Reference: TR010037
A11/A47 Thickthorn junction

I am commenting on Work 35, the replacement bridge across the A47.
The bridge being replaced was only for carrying Cringleford Public Footpath 4a when built.

Figure 1. Proposed footbridge

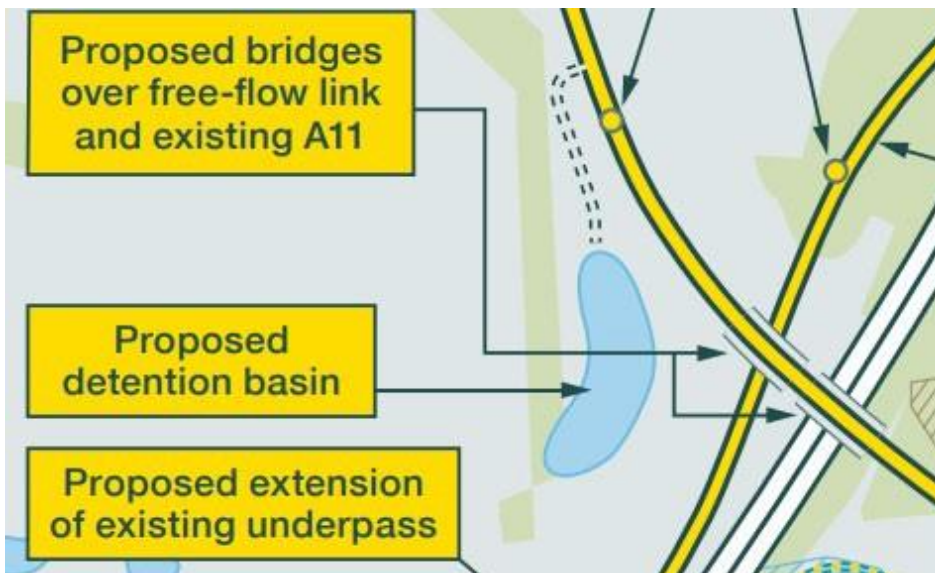
A new estate is being developed off Cantley Lane on the Norwich side of the A47. Therefore we think the replacement bridge should be built to at least a cyclepath standard, as well as being able to carry pedestrians and mobility assistance vehicles.. Although horse riders may be in a minority, if the bridge is to be designed for cyclists, it may as well be designed with sides high enough to take horse riders safely. If this is what the scheme provides for, we support it.

We also think that for extra safety for the traffic underneath as well as those using the bridge, it should be meshed over the top as well as the sides.

We would prefer if possible for the new bridge to be completed before the old bridge is demolished.
